DECISION DELEGATED TO HEAD OF PLANNING

Application No: H14-0450-22 **Applicant:** P N Holdings Ltd.

Proposal: Residential Development - Erection of Dwelling (re-submission of H14-0811-21)

Location: Adj. 47 Milestone Lane Pinchbeck Spalding

FLOOR PLANS & ELEVATIONS  
SITE & LOCATION PLANS.

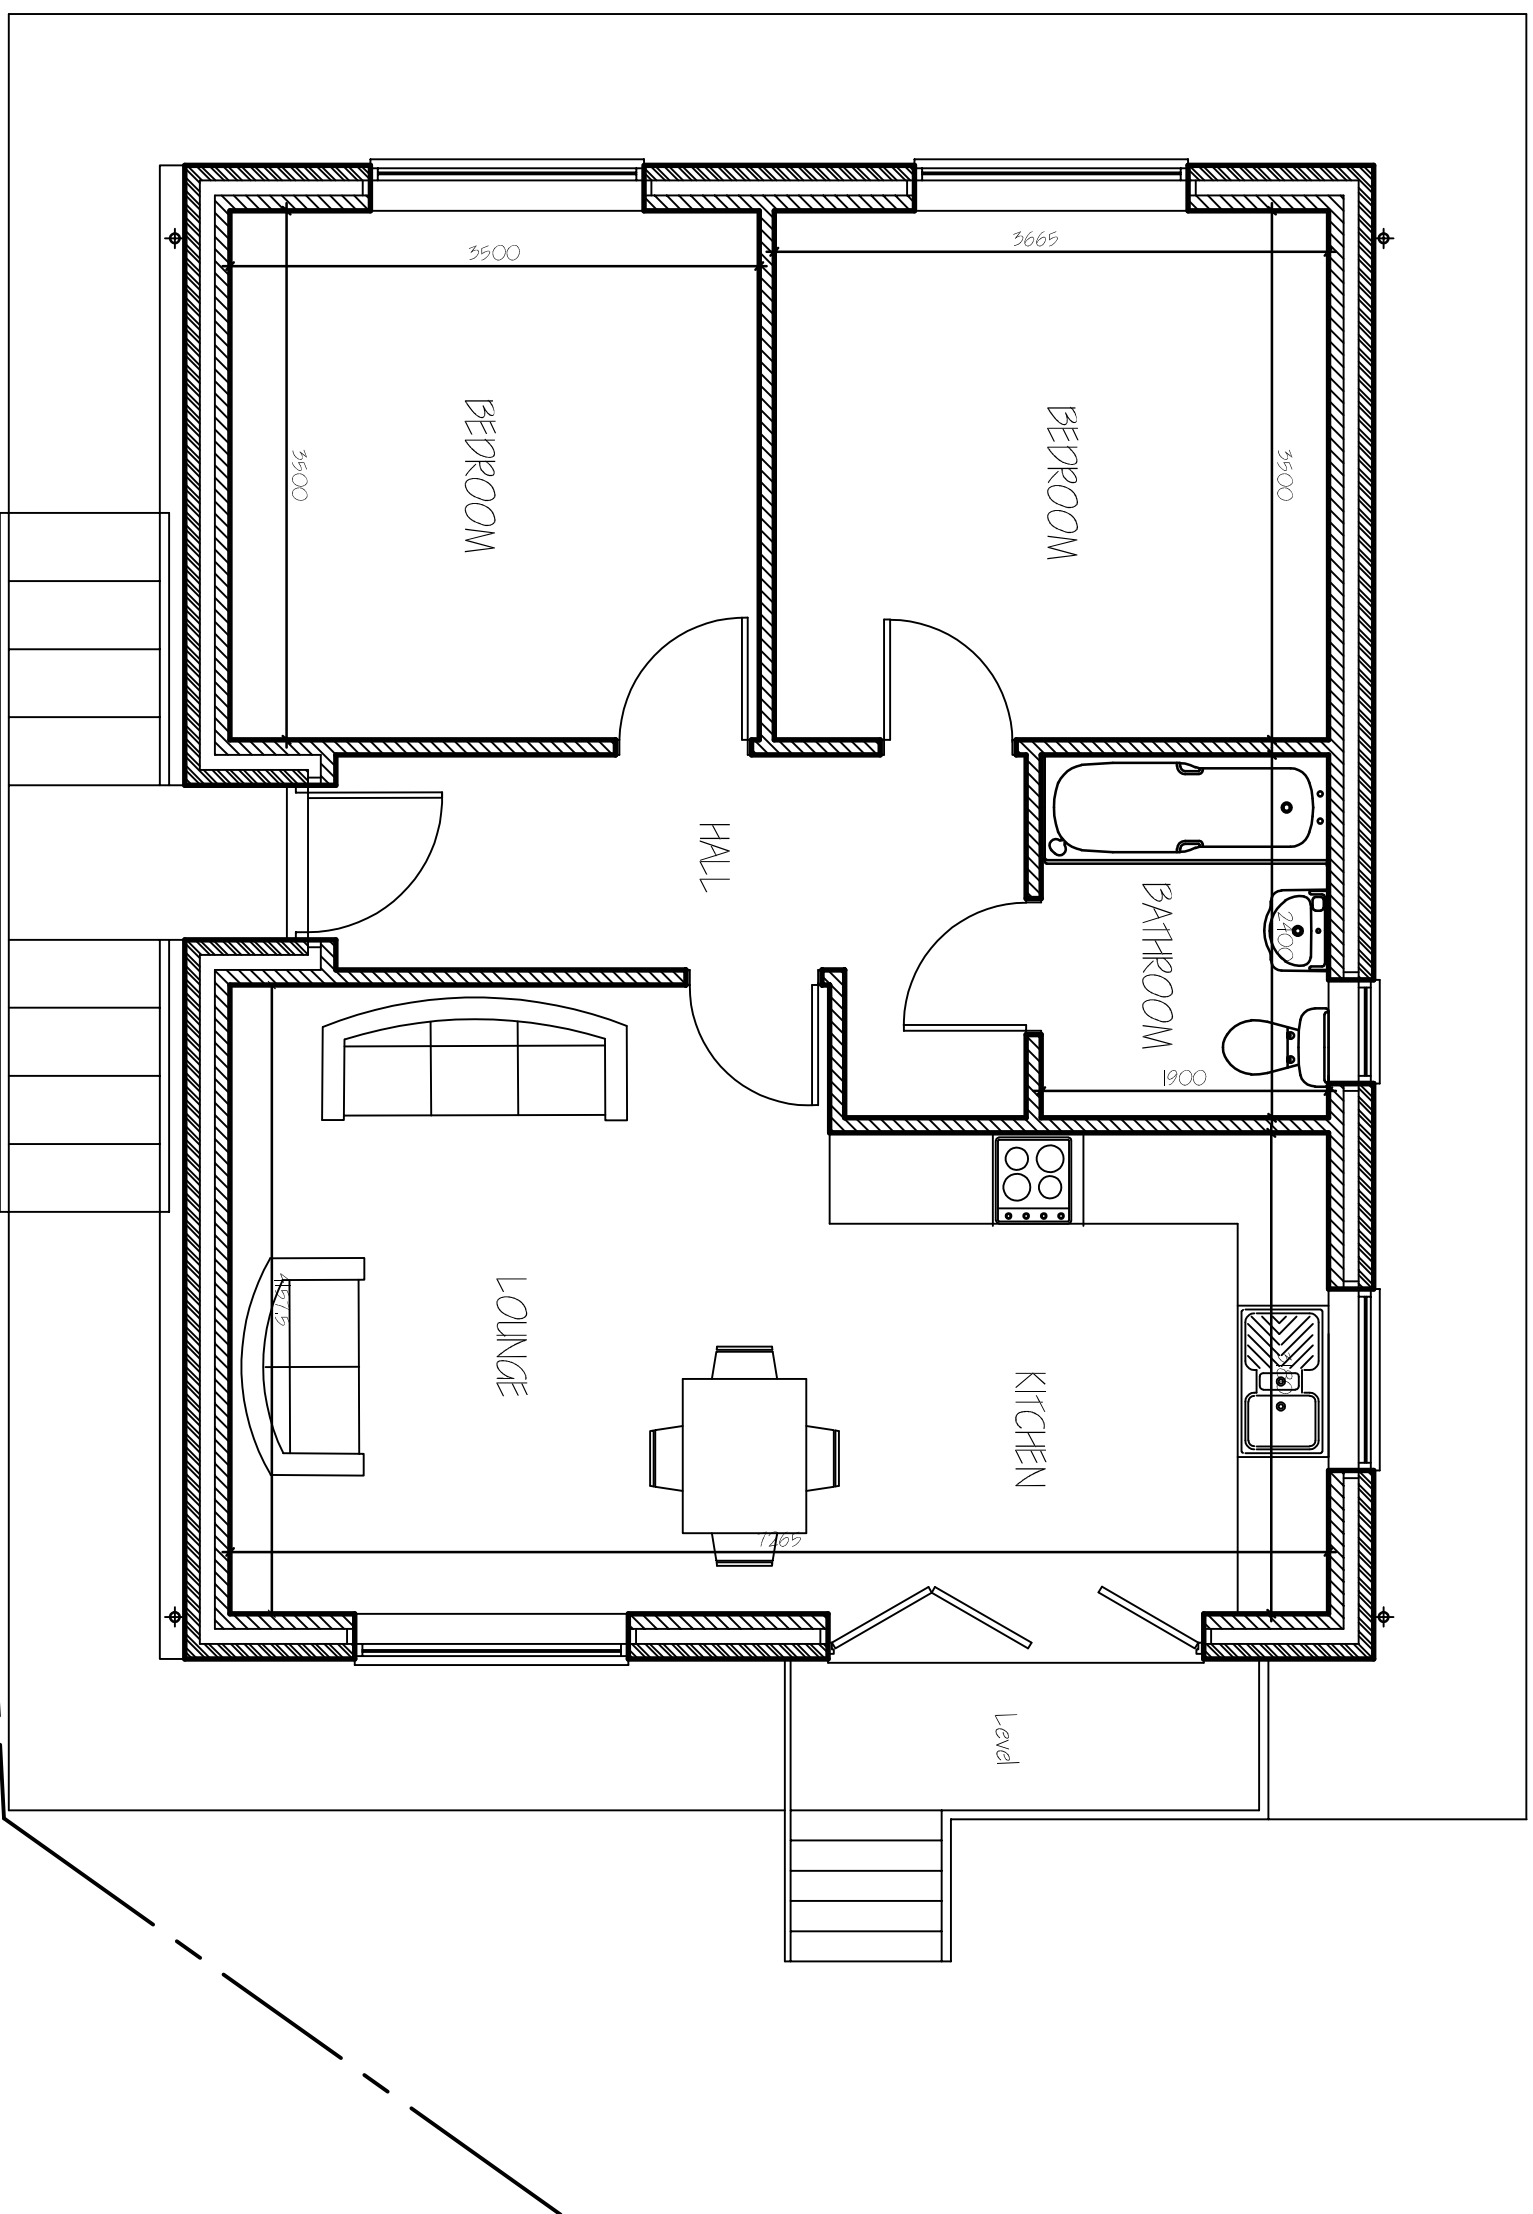
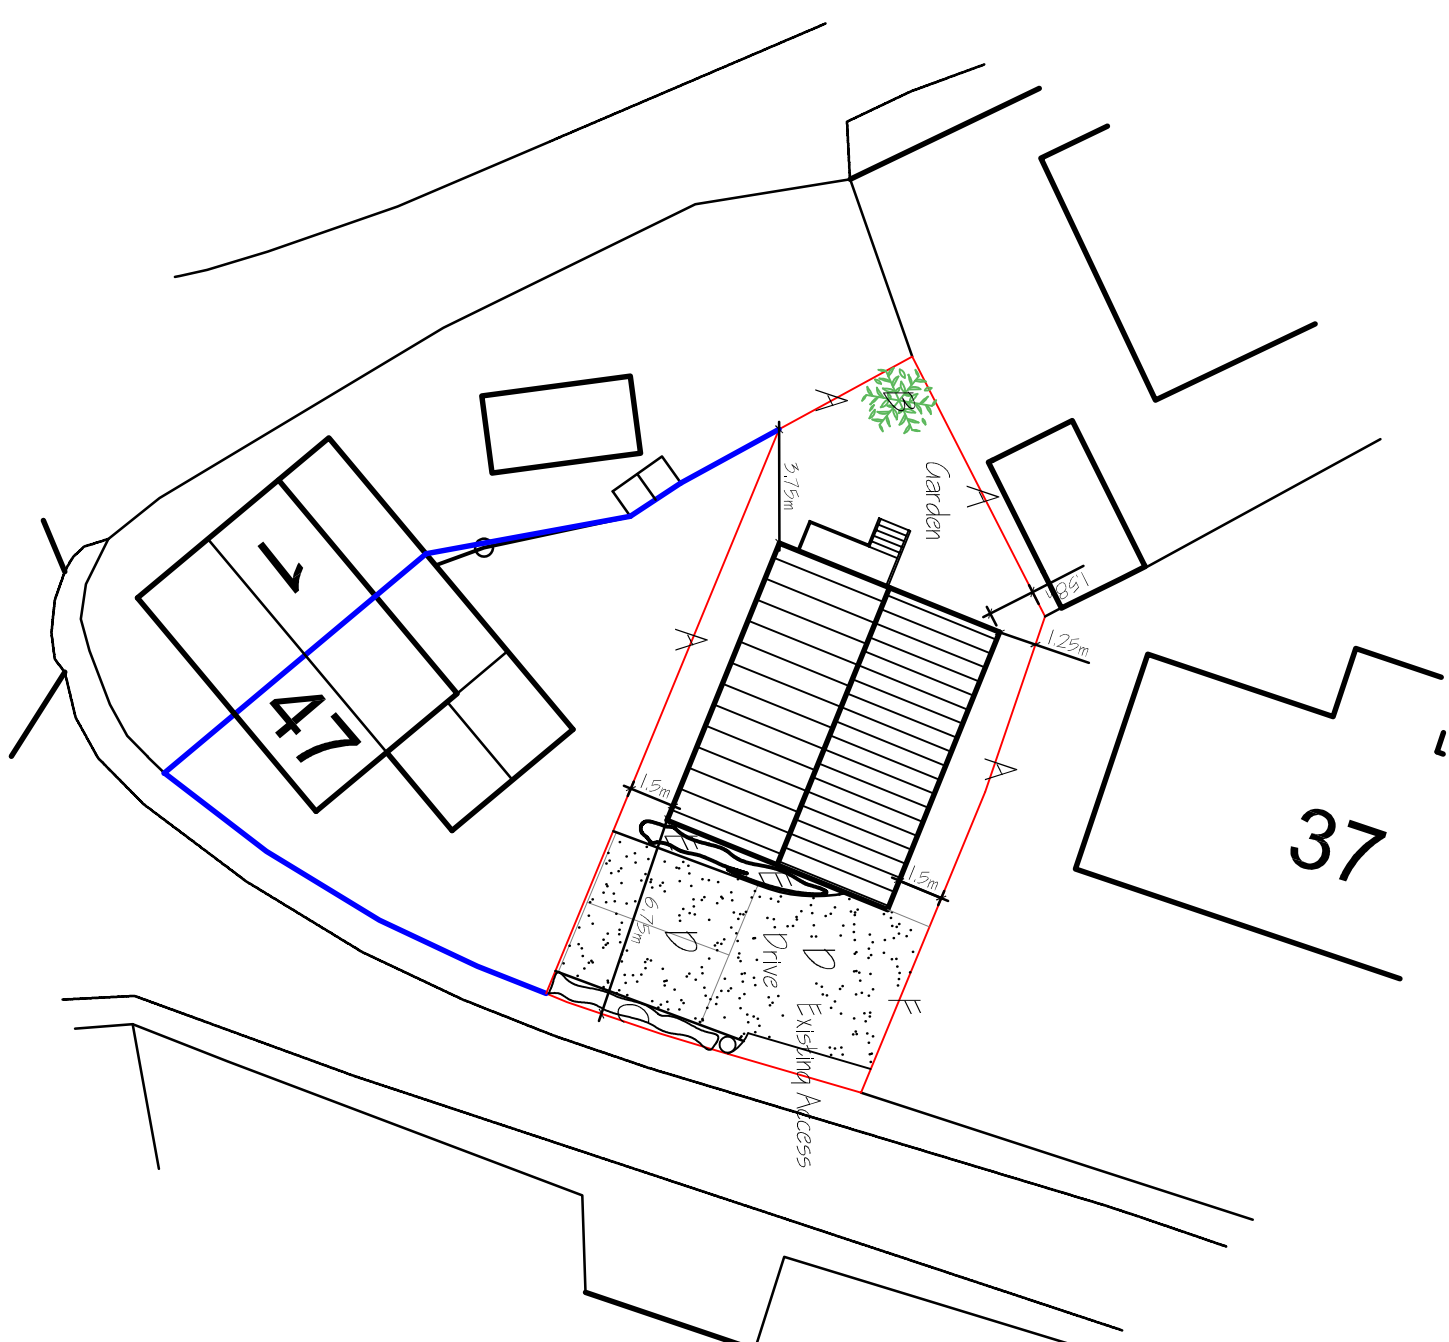
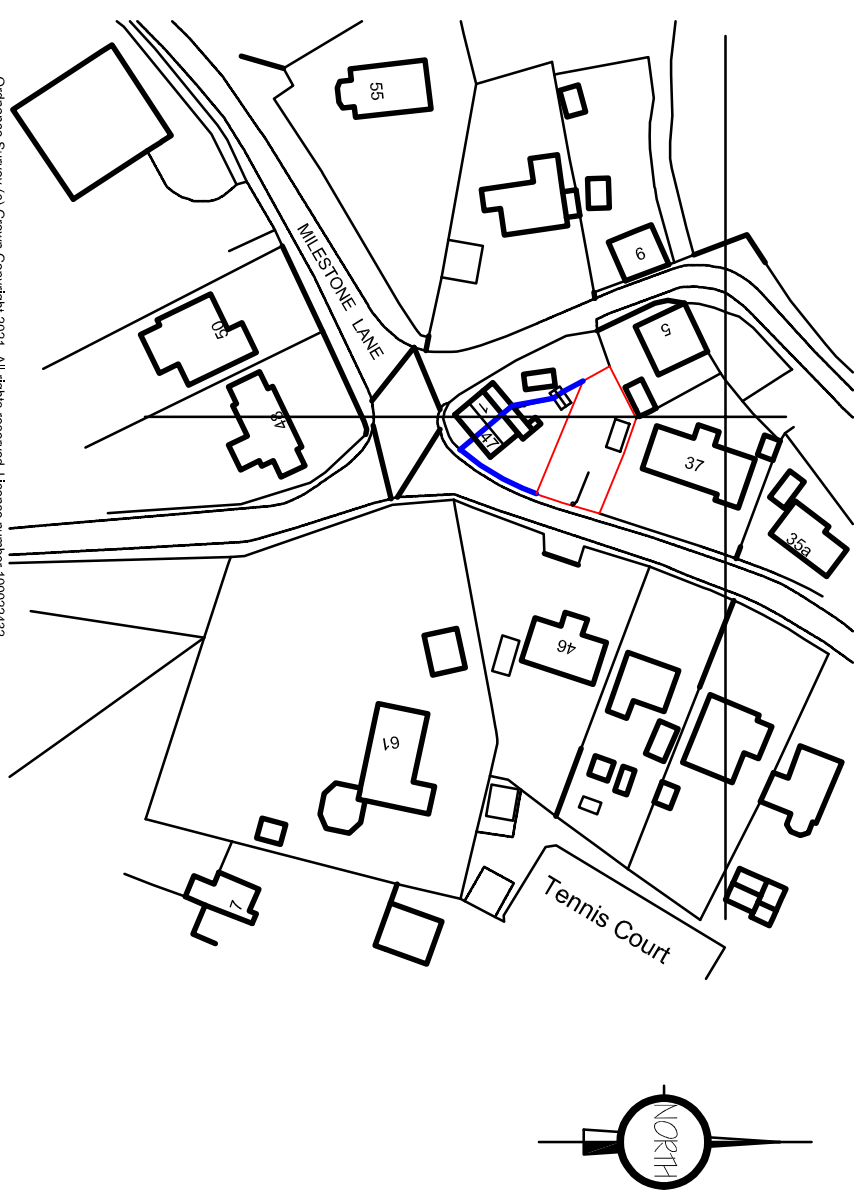
The proposed dwelling will measure approx. 9.8m in depth by approx. 7.7m in width. The overall depth of the site measures a maximum of 23.4m in depth and a overall width of approx. 10.8m. The northern side elevation of the proposed dwelling is approx. 5m away from the side elevation of the property at no.37 and approx. 4.1m to the side elevation to the property to the south.

Existing houses on this part of Milestone Lane (as well as Bacons Lane) are typically situated on larger plots than the application site (the narrowest currently being approx. 10m in width). It is considered that the proposed dwelling would appear visually cramped within the plot and would be at odds with the character of existing development in the locality. In terms of the design of the proposed dwelling, due to the predicted flood depths, there is stepped access in order to enter the dwelling which is not in keeping with the design of other dwellings in the vicinity.

The proposed boundary treatment to the sides and rear of the dwelling is 2m closeboard fencing with 500mm trellis above. Given the need to raise finished floor levels by 1m, this would be sufficiently high enough to prevent overlooking from the side facing ground floor windows to the neighbouring garden. The bottom half of these windows would be below the trellis, however, there

are no side facing windows that would be a material overlooking to the neighbouring garden (utility room classed as a non-habitable space).
